ENVIRONMENT PROTECTION AUTHORITY

Our reference: EF13/3374
Contact: Brad Tanswell 02 6883 5367

Thank you for the opportunity to comment on the Response to Submission Report (RtS) associated with the proposed Northparkes Mine extension (ref MP11_0060) received by the Environment Protection Authority (EPA) on 24 October 2013.

Note: 1. Commercial agreement in place with resident over life of Project.
2. Receiver 5 – Bonnie Doon owned by NPM and not included in the noise modelling results.

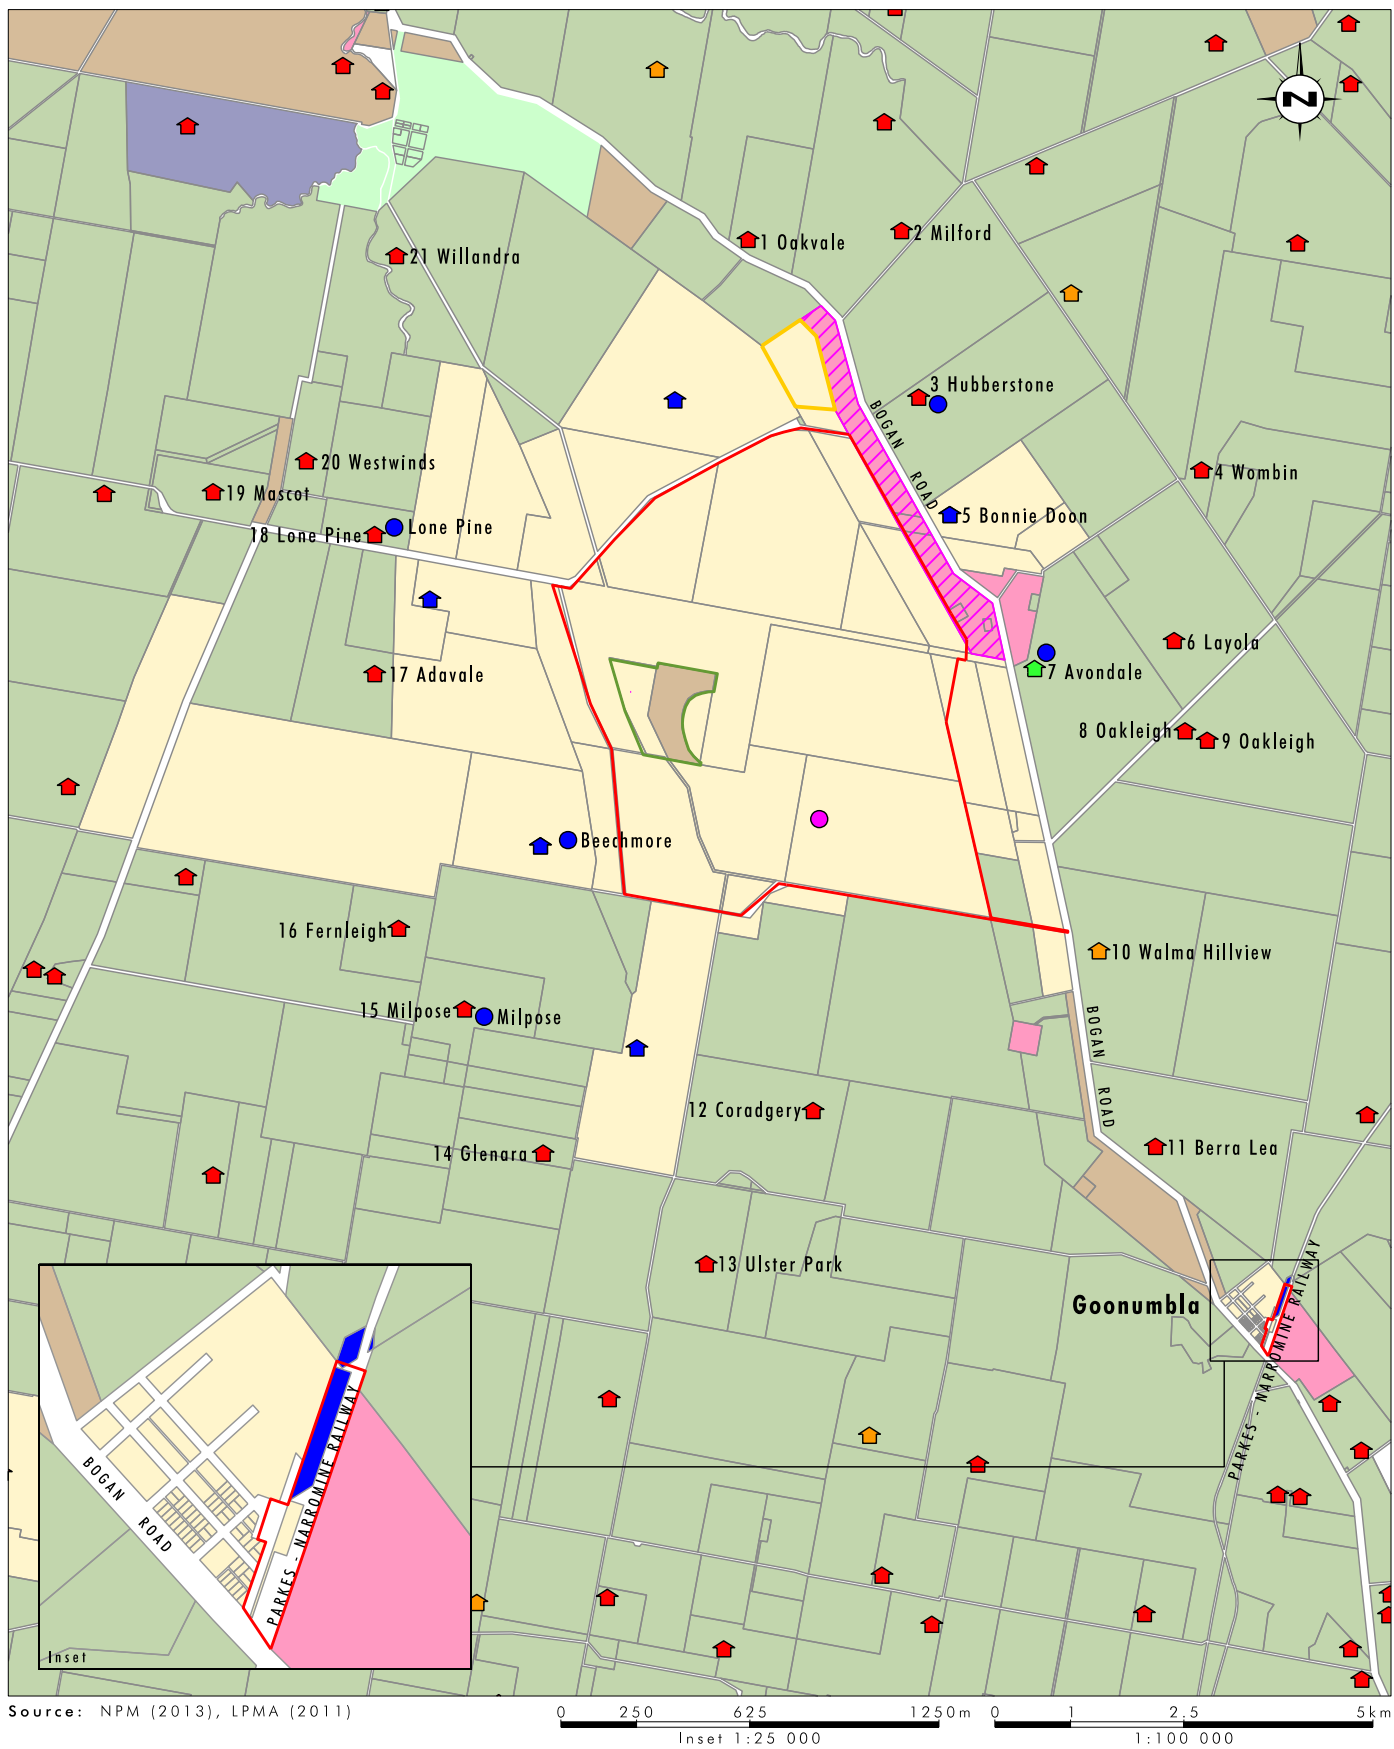
Sensitive receiver not included in Noise Impact Assessment (NIA)

The RtS addresses a submission by Annette Moss, owner of the "Hillview" property, which includes a building ("Walma Hillview") identified as a derelict residence in the NIA. The submission highlighted that the NIA assessed impacts on "Walma Hillview" but not on an existing occupied residence or a proposed new residence on the property. In response to Ms Moss' submission, the RtS assesses the operational noise impact of the proposal on the existing occupied residence on "Hillview" as well as the proposed new residence.

The RtS provides sufficient information to demonstrate that operational noise from the proposal including Tailings Storage Facility (TSF) construction and campaign open-cut mining will comply with PSNL. However, the RtS does not address impacts on existing and proposed residences on the "Hillview" property resulting from construction of the modifications to McClintocks Lane (a public road) and the new site access road (a private road).

The information provided on residual impacts above the PSNL in the RtS appears to be applicable to sensitive receiver locations on the "Hillview" property, including during installation of the private access road, and the Construction Noise Management Plan proposed in the NIA and RtS should deal adequately with impacts above the NML during construction works on McClintocks Lane.
